Application for a Non-Material Amendment Following a Grant of Planning Permission

Stand Alone Storage Unit

CHE/20/00270/FUL

Lowering of roof and addition of windows to building

Project Number 24.009	Drawing Number PL06
---------------------------------	-------------------------------

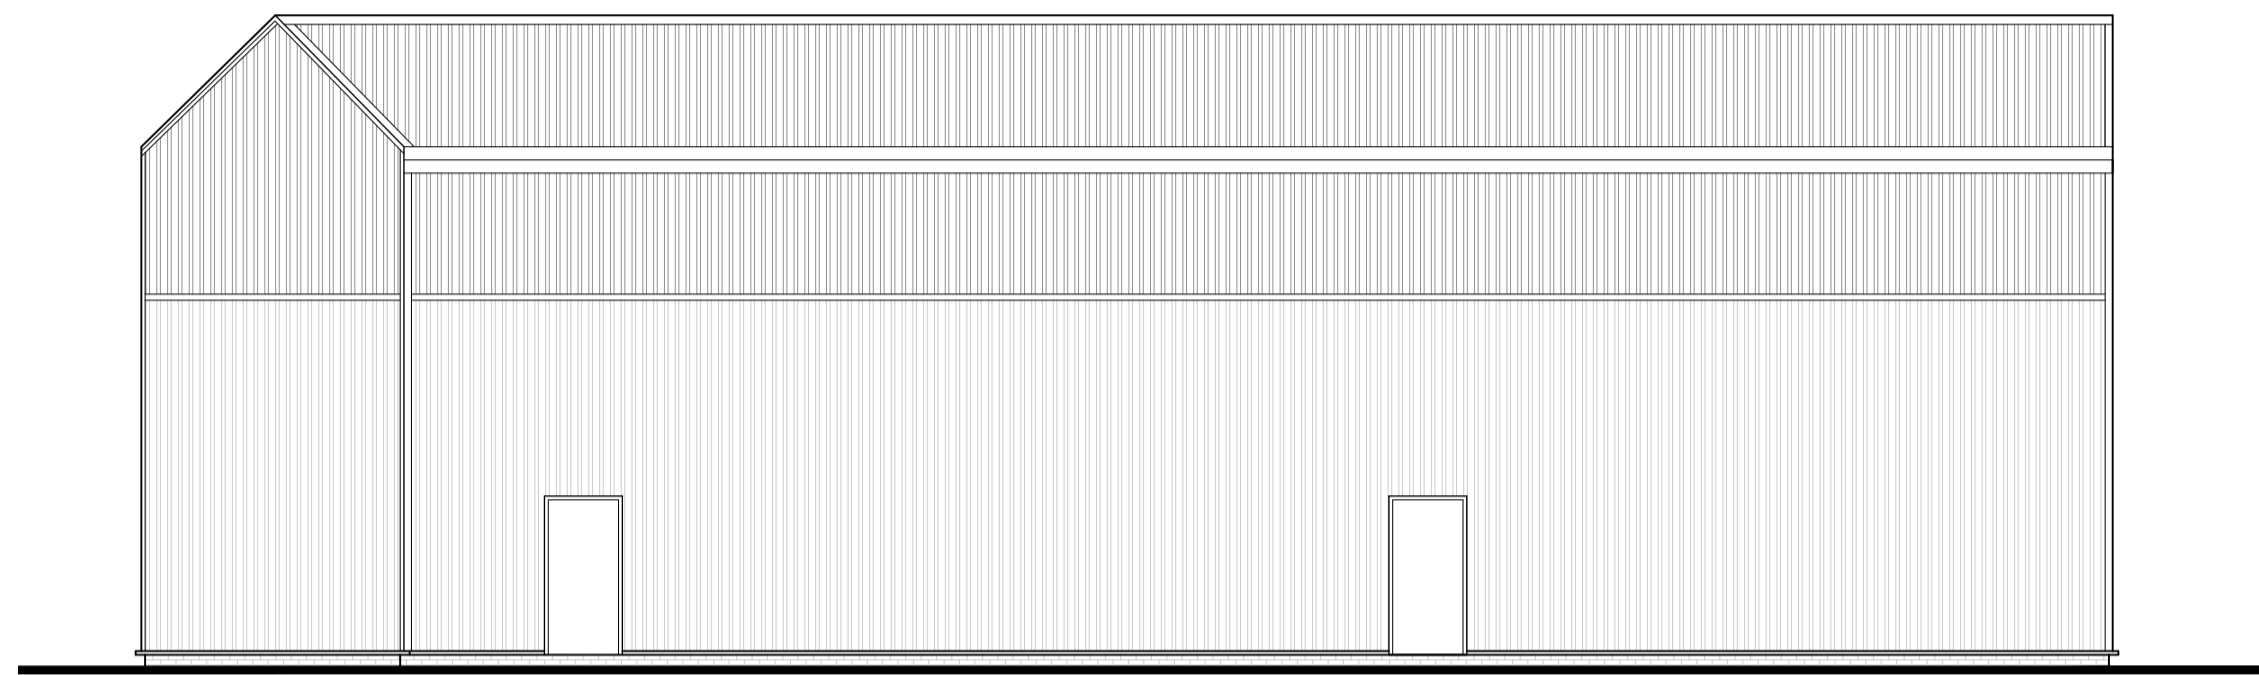
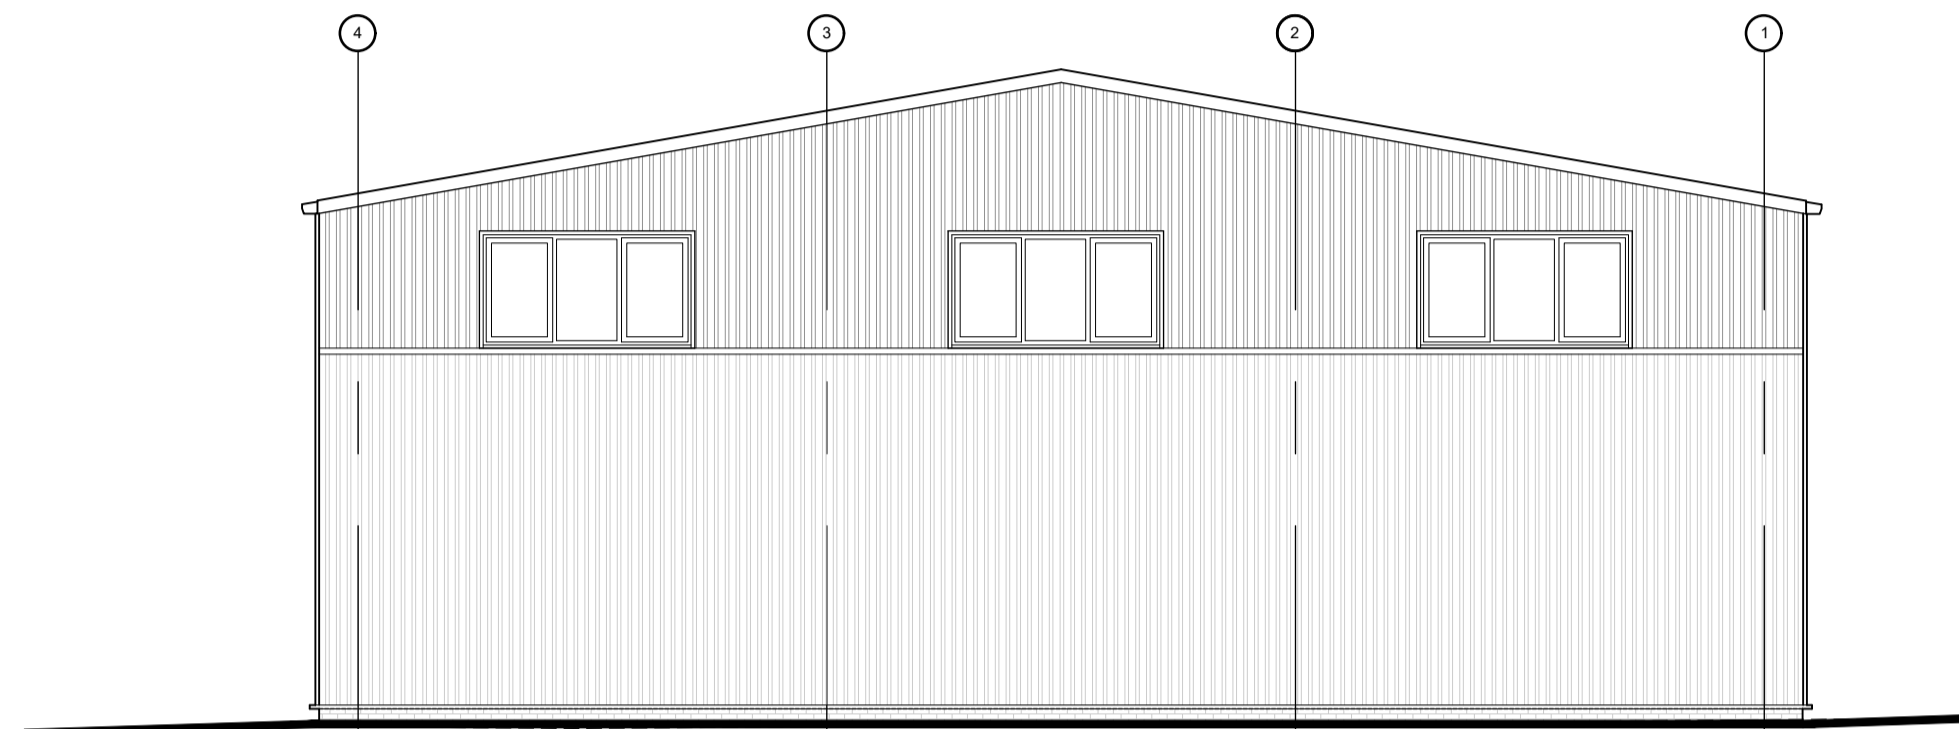
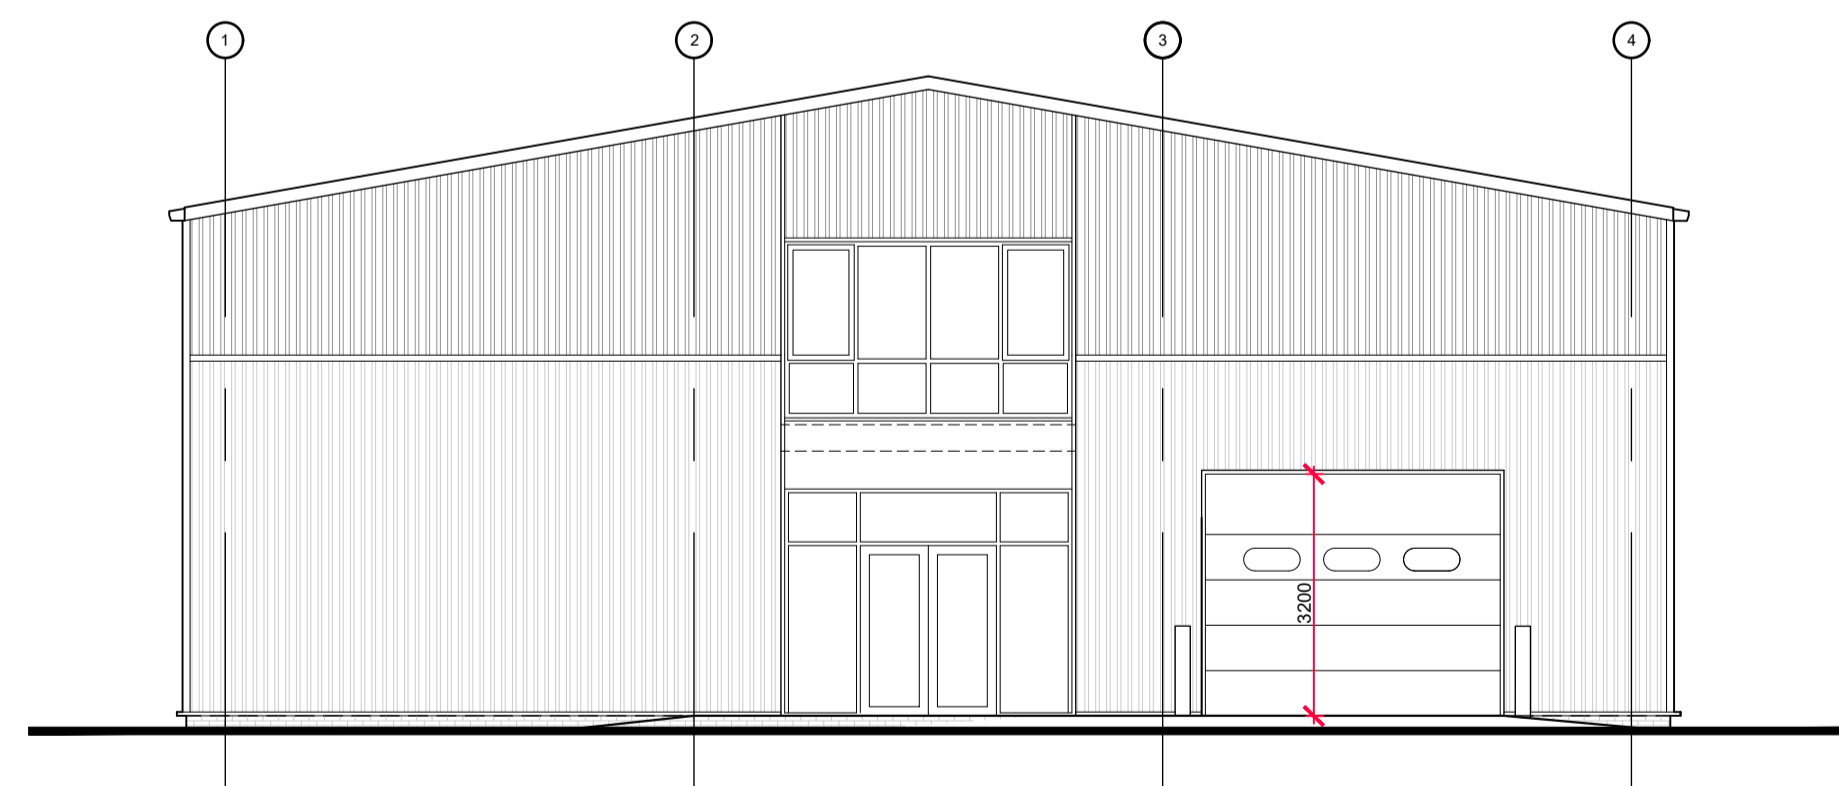
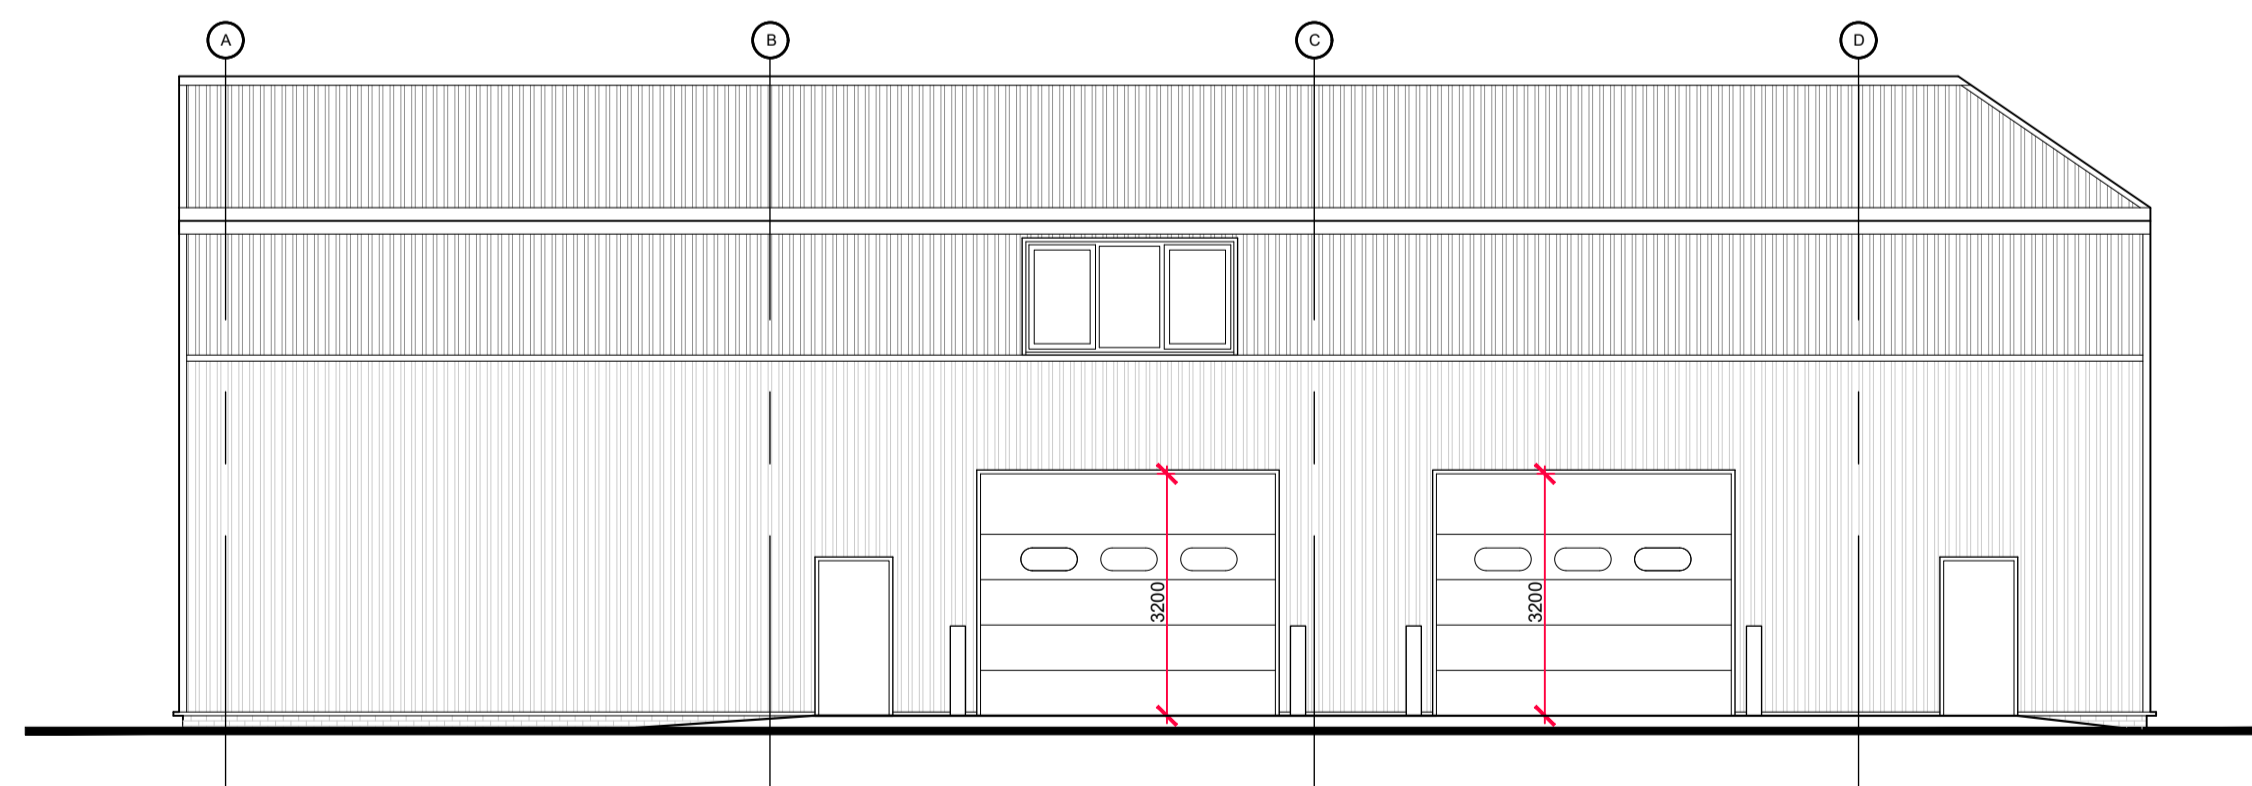
11m eaves height no longer a requirement and additional windows to allow natural light
